DOC19/839420-4

Date: 22/10/19

SSD-9143 – Poultry Processing Mixed Use Development EIS at 52 Sinclair St, Goulburn – EPA Comments

EROSION & SEDIMENT CONTROL PLAN  
 PROPOSED PROCESSING FACILITY  
 52 SINCLAIR STREET,  
 GOULBURN  
 WOODLAND RIDGE POULTRY PTY LTD

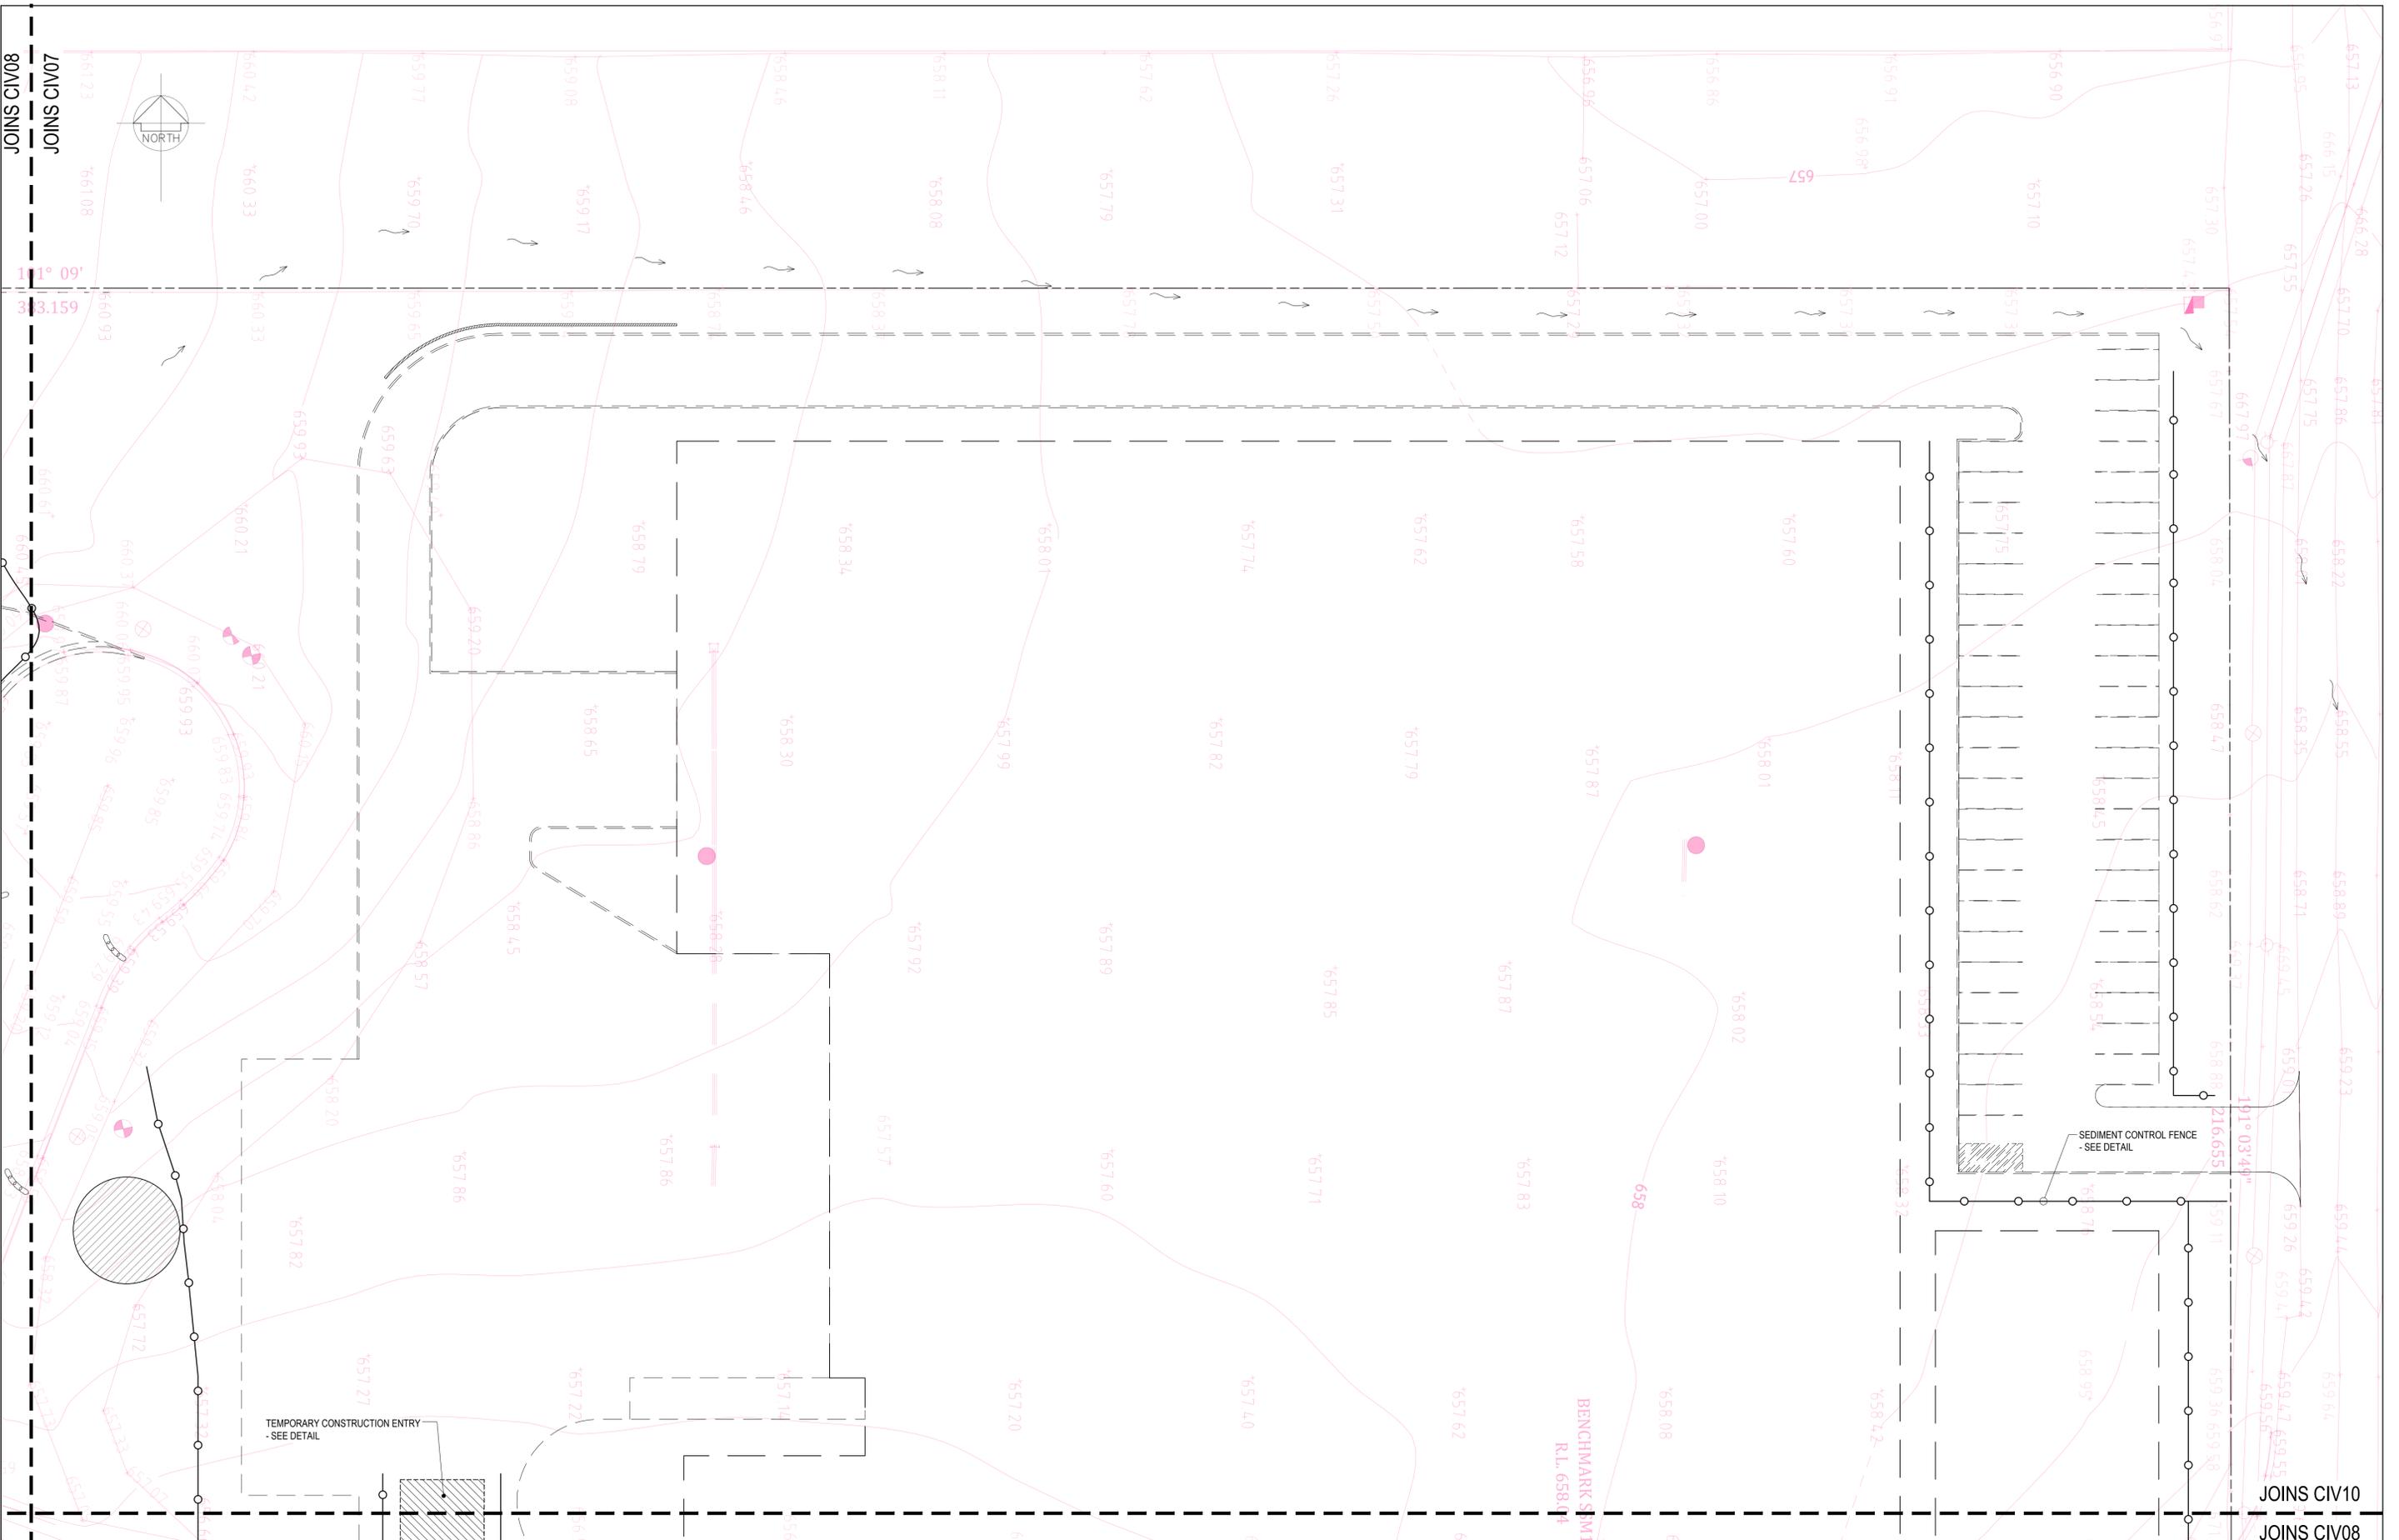
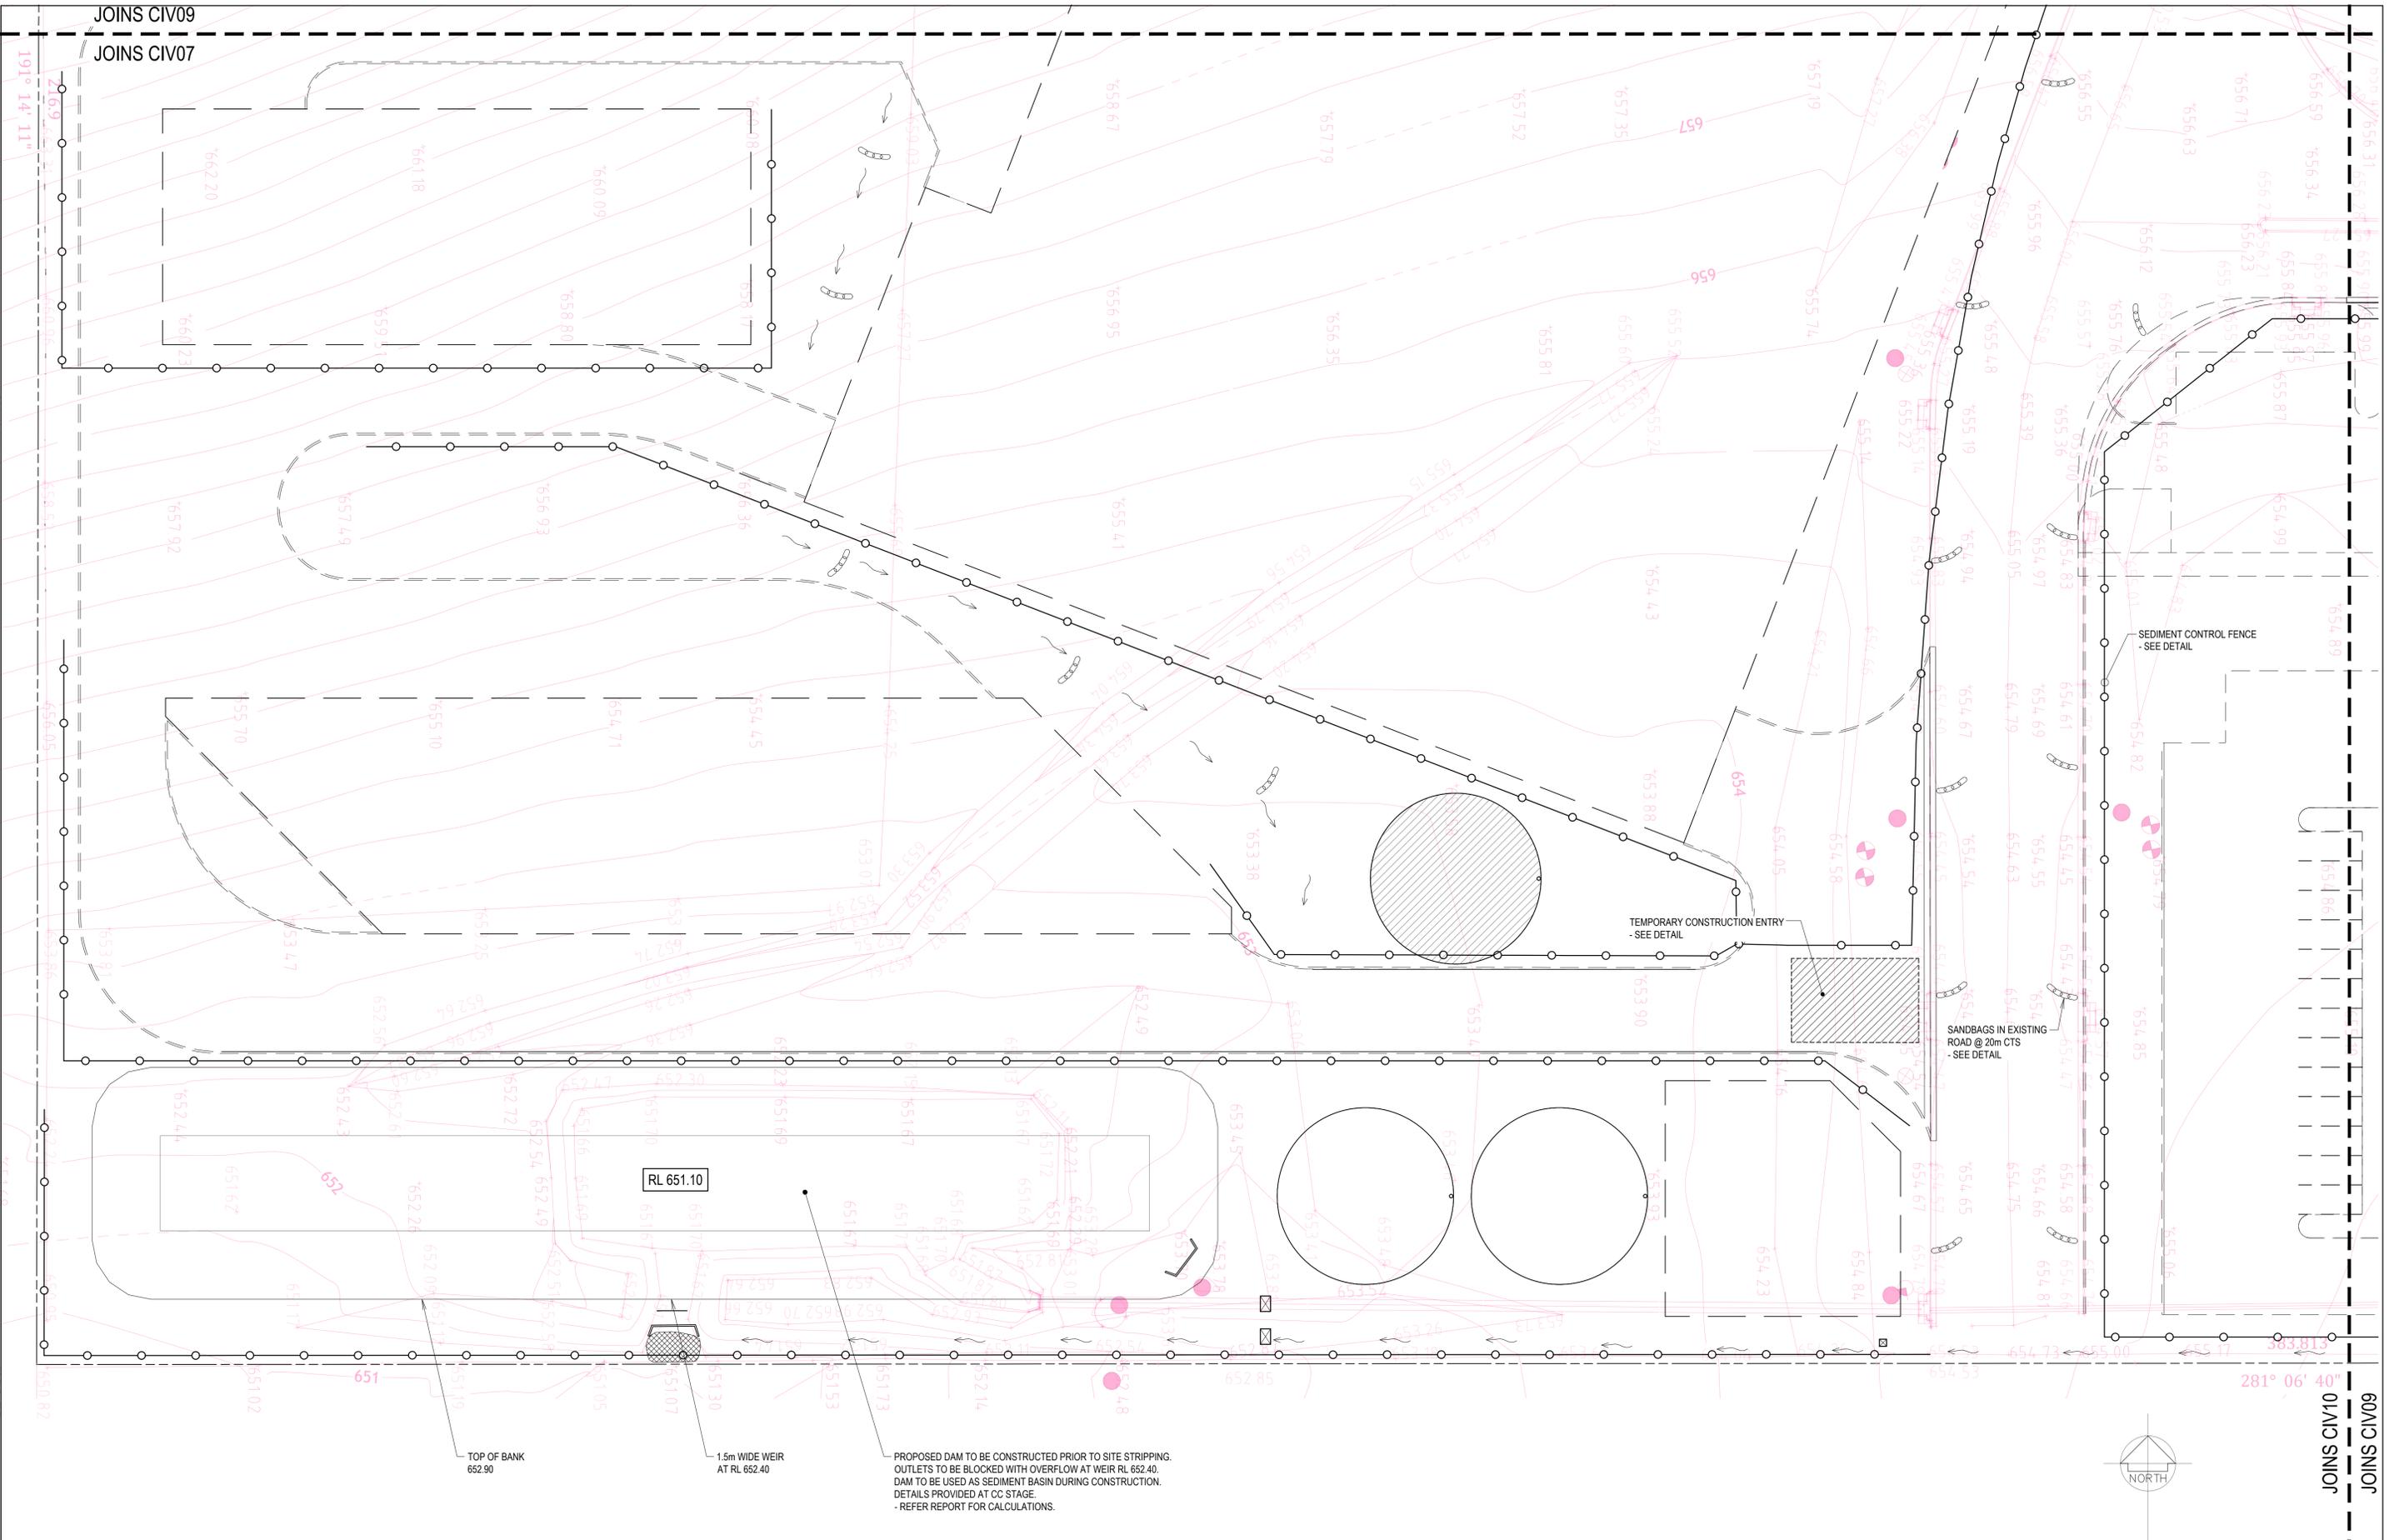
The EPA notes that a stormwater dam for the premises is going to be constructed to replace the existing dam and will serve as a sediment basin during construction of the premises. In the document accompanying the EIS and titled *Appendix B – Civil Engineering Plans*, there is a nominated procedure to discharge water from the basin and meet the limits of 50mg/L TSS, 6.5-8.5 pH, 60NTU for turbidity, and have EC levels no greater than background levels.

The EPA notes that EIS does not include a water quality objective assessment for proposed discharges from the sediment basin during construction. In addition, the associated documents have not considered alternative ways to dewater the sediment basin during construction.

The EPA recommends that the proponent undertake a water quality objective assessment as per the requirements of the EPA's SEAR's for the project. The EPA also recommends that the proponent describe all reasonable and feasible mitigation measures to be put in place to prevent any impacts to surface water or groundwater.
